To: Margaret Haynes, NMDOT Assistant District 3 Traffic Engineer

From: Chuck Huffine, PE, PTOE

Date: March 31, 2022

Re: 3/17/22 Comment Responses – Coffee Shop Development Traffic Impact
Study Northeast corner of NM 45 (Coors Blvd) and Brayton Rd
Albuquerque, New Mexico

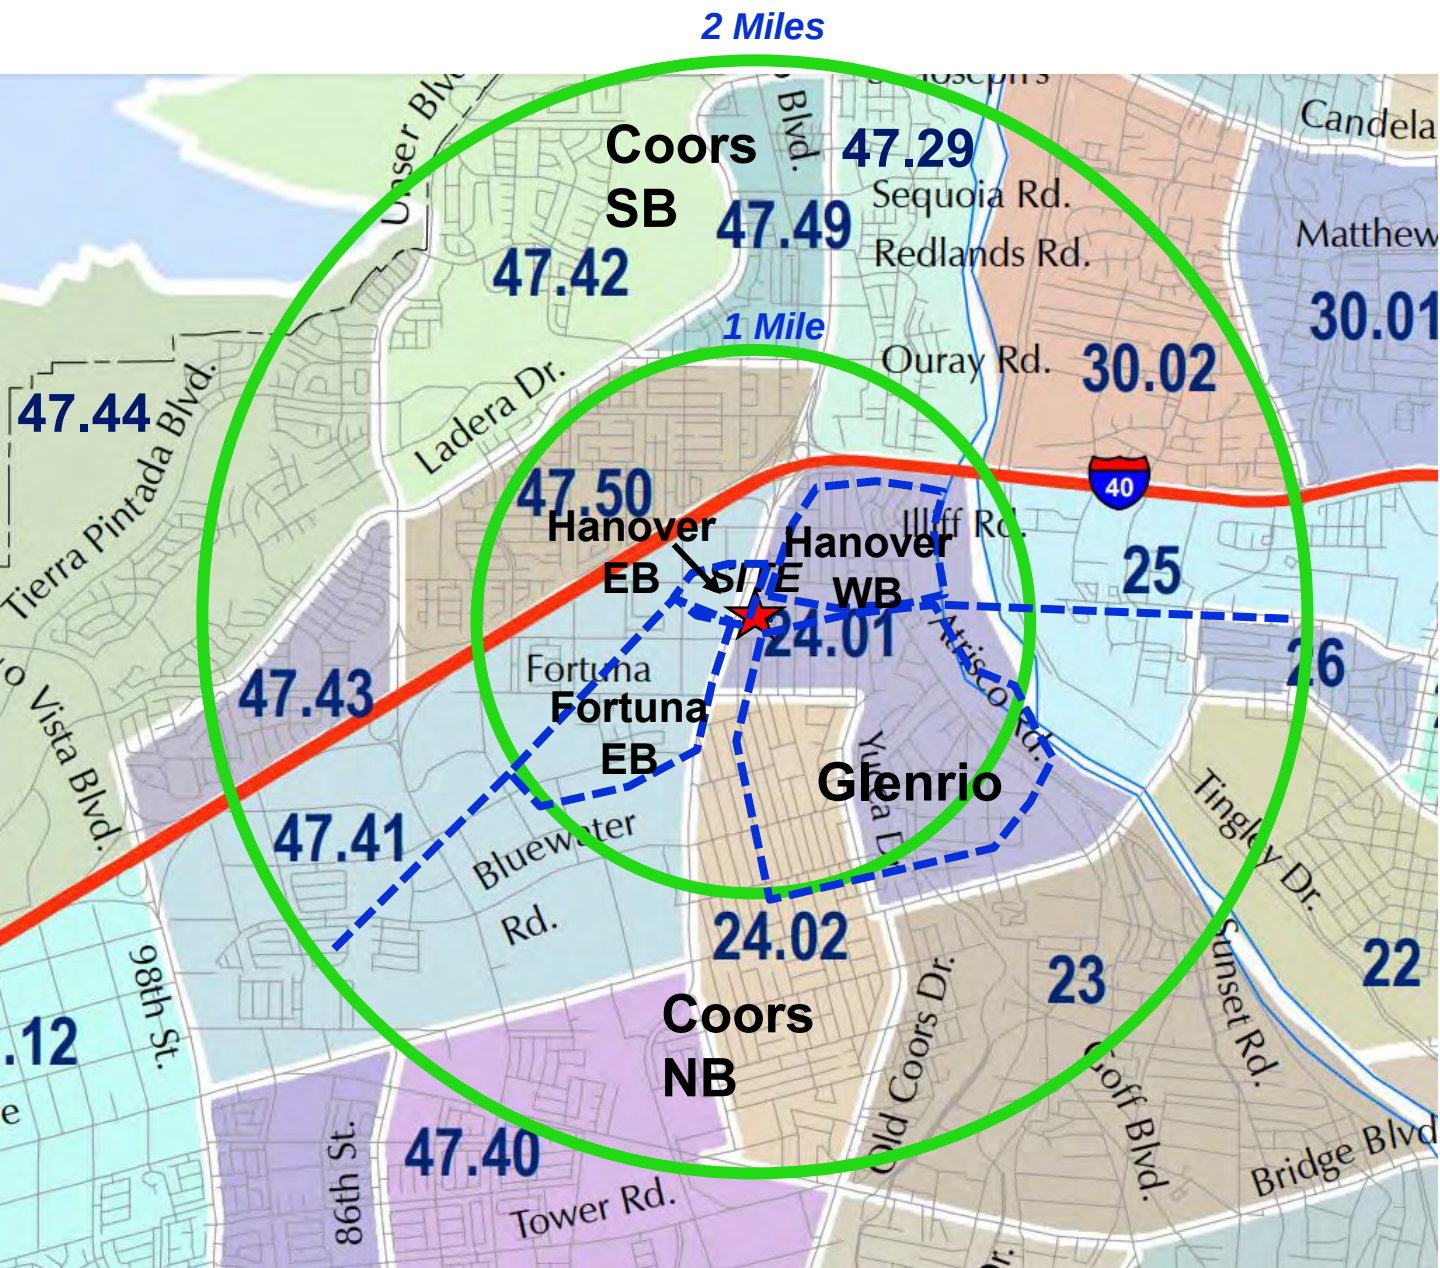
- 3) Include site plan within body of the report.

Response: Included as Figure 2.
